Zoning Division
Marge Schmuckal
Zoning Administrator

June 14, 2002

RE: 8 Marriner Ct., Peaks Island, ME - 090-B-002 - IR-2 Zone

1 PROPOSED FLOOR PLAN
 SCALE: 1/4" = 1'-0"

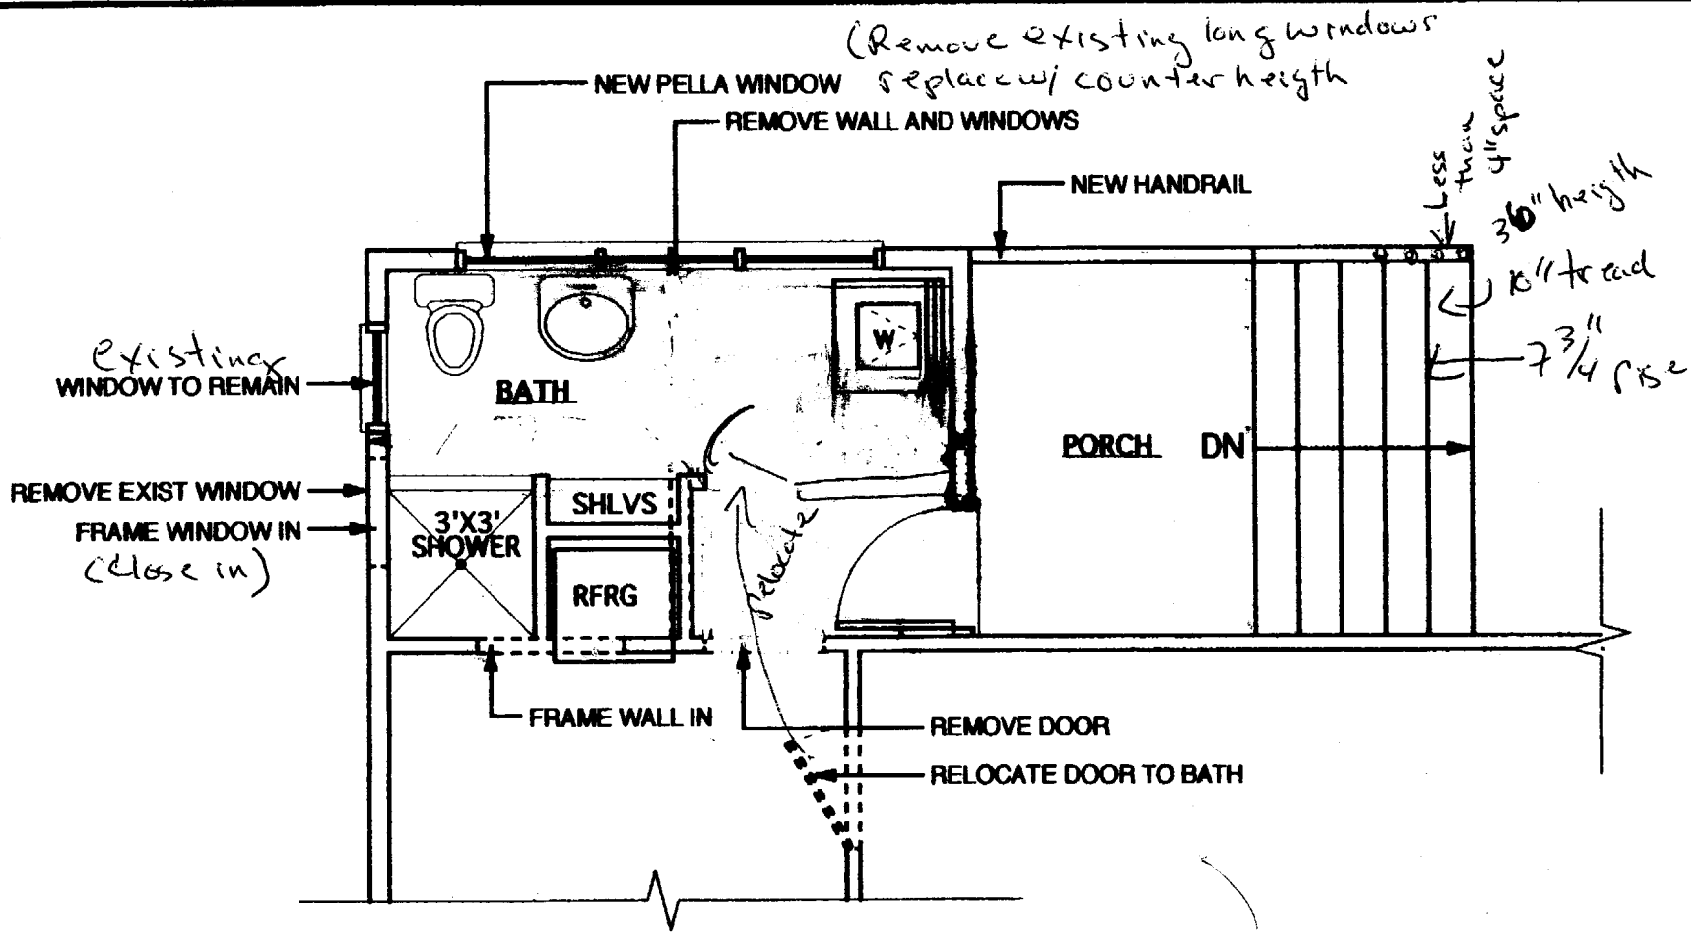
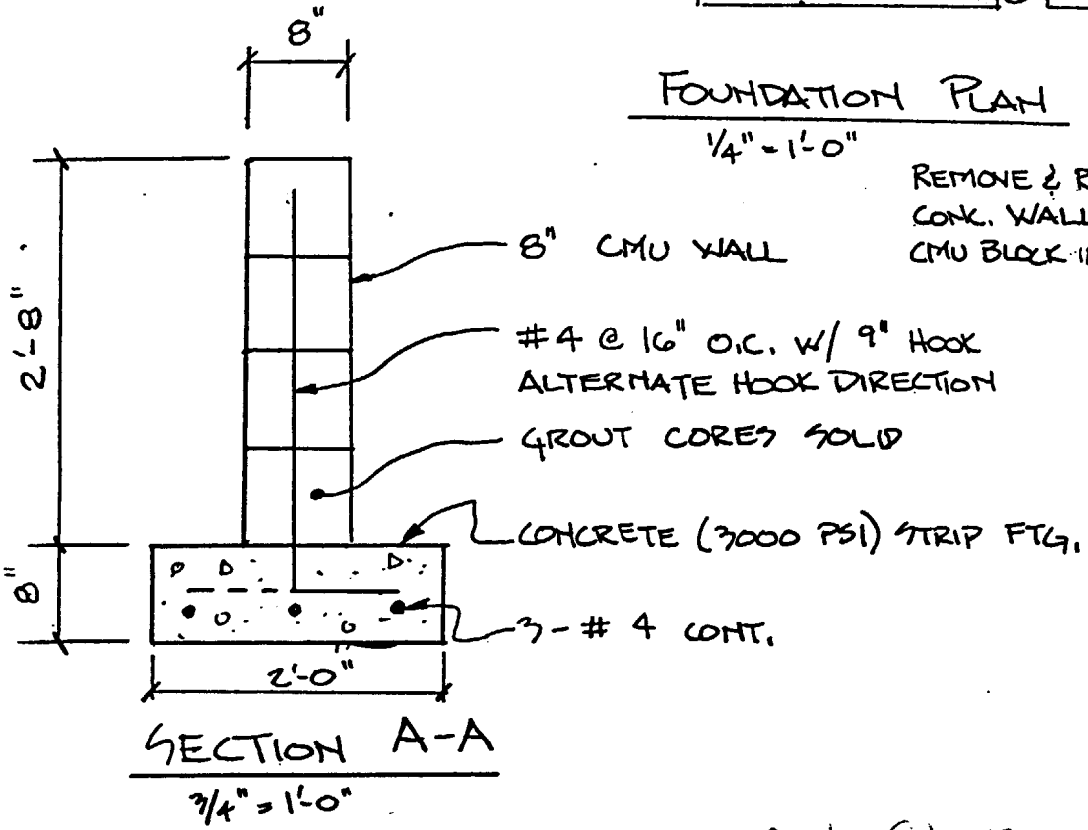
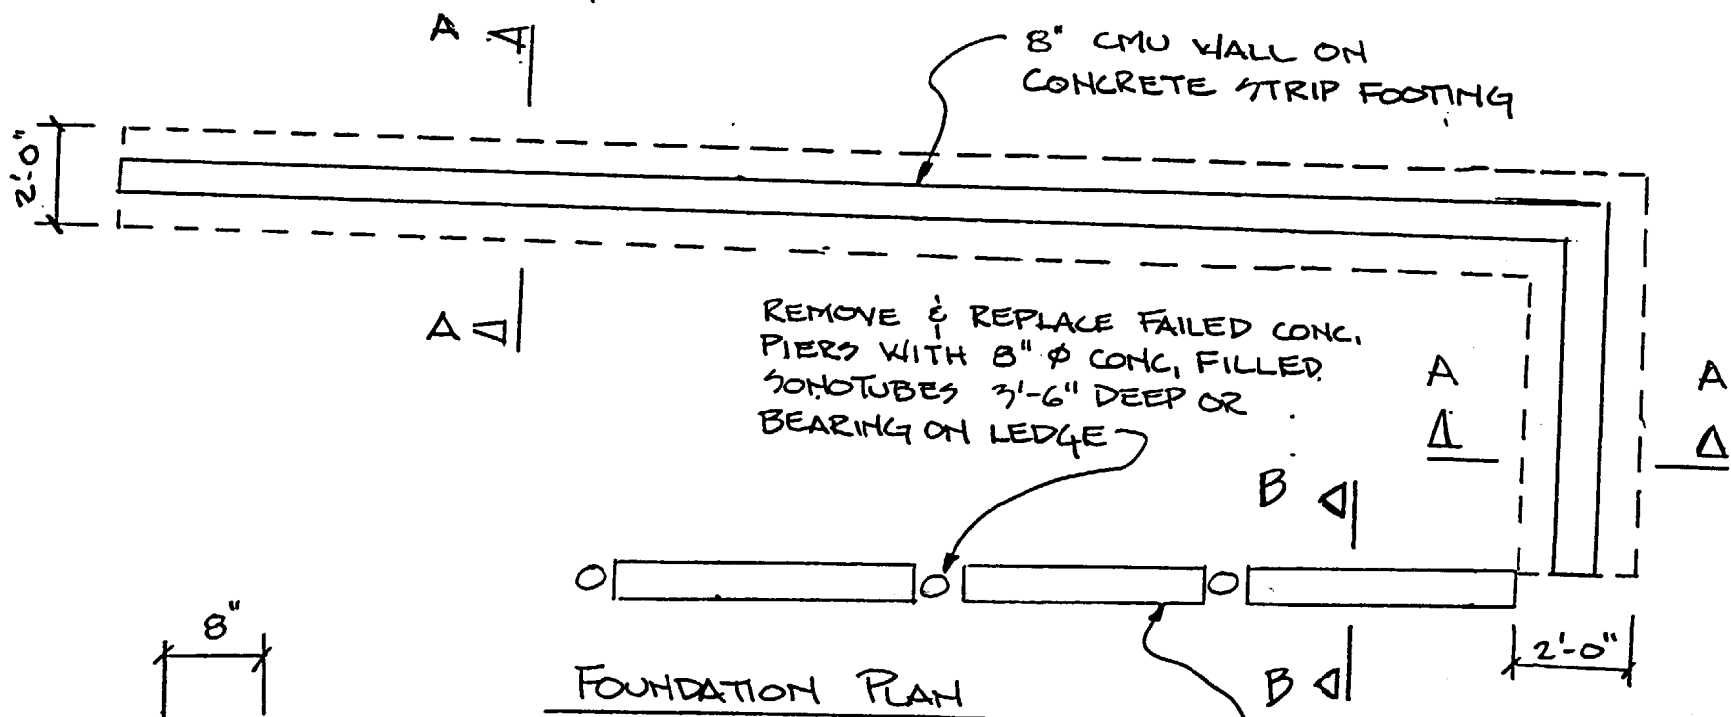
You would also need to document more clearly on the plans, which porch is being enclosed. This area, if it is within the 75' setback, will count toward an increase of at least your volume.

*This is porch
closest to "street"
not ocean -*
